Application for a Non-Material Amendment Following a Grant of Planning Permission

Amendment to window heights in front and rear elevationa

22/00072/FUL

Project No:	Drawing No:	Revision No:	Scale:
21-005	A.E.100	06	1:100 A3

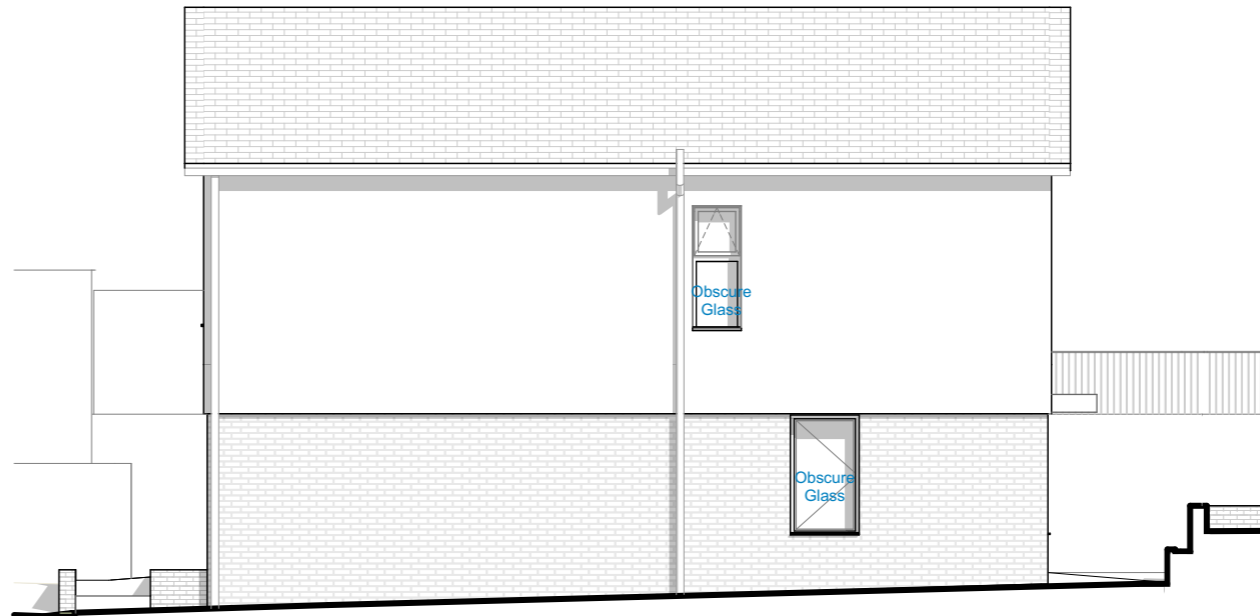
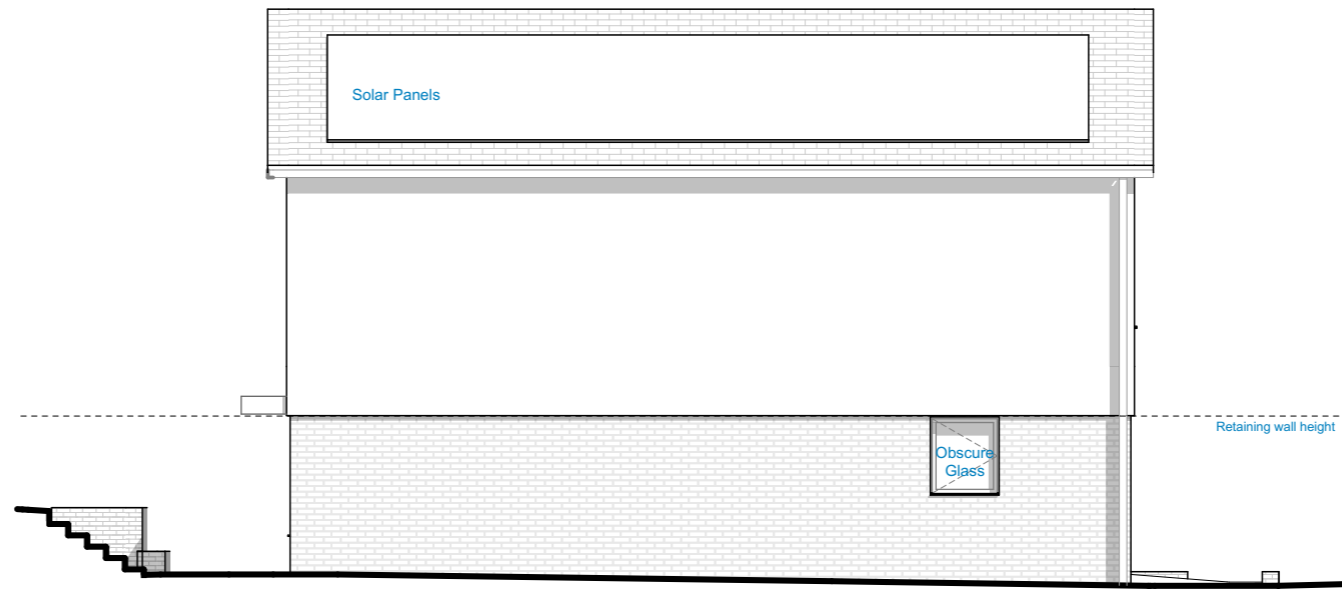
Alterations to window heights in front and rear elevations

Full height windows in shower room and bedrooms are not practical.
